From: dc.support@cherwell-dc.gov.uk
Sent: 19 May 2022 10:13
To: DC Support
Subject: New comments for application 21/01630/OUT

New comments have been received for application 21/01630/OUT at site address: Land at North West Bicester Home Farm, Lower Farm and SGR2 Caversfield

Drawing Title
Development Parameter Plan 3 :
Access and Movement

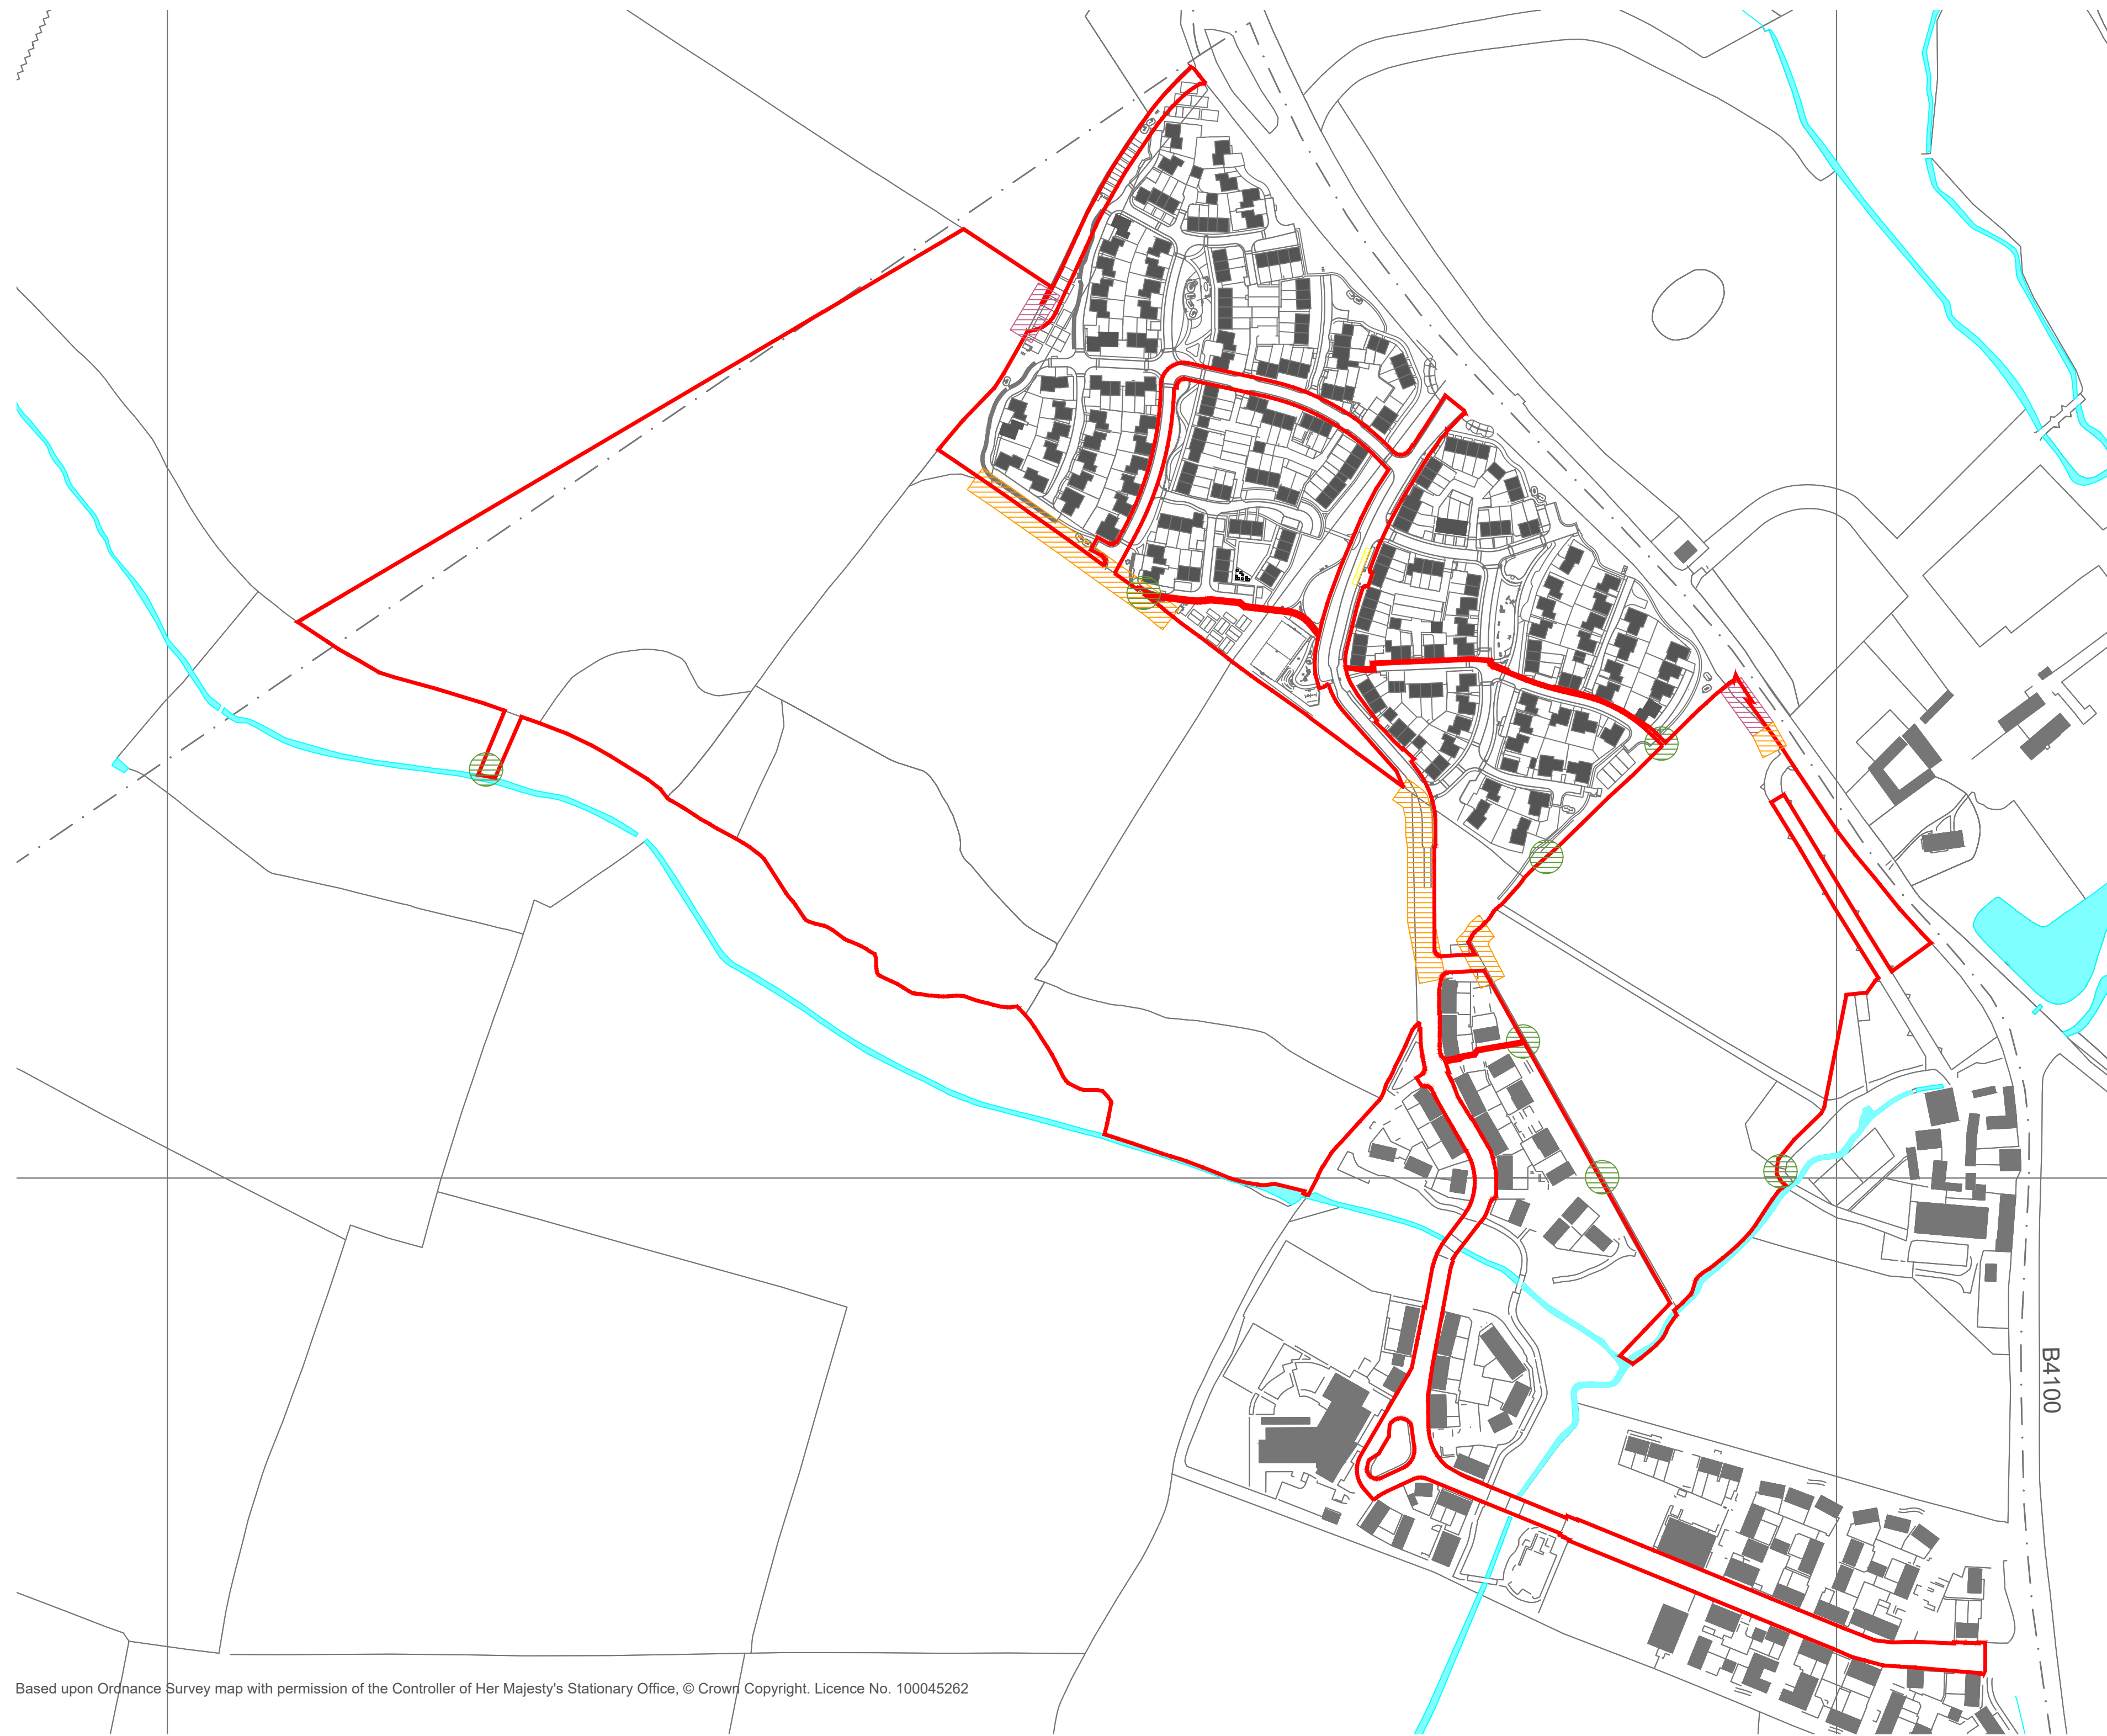
The traffic jams at the School and B4100, 8-9am, will be made exponentially worse if this number of new homes are allowed to connect onto Elmsbrook, as per the current design. The situation is already bad, and the school is only 40% full - it will get worse in future years anyway, and more than tripling the number of homes beyond it served by Charlotte Avenue will clearly make things much worse, i.e. dangerous. It's just not viable. The road network must be analysed properly, joined up with the Hawkwell Village analysis as well - otherwise both applications' traffic assessments are meaningless: the problems interact!
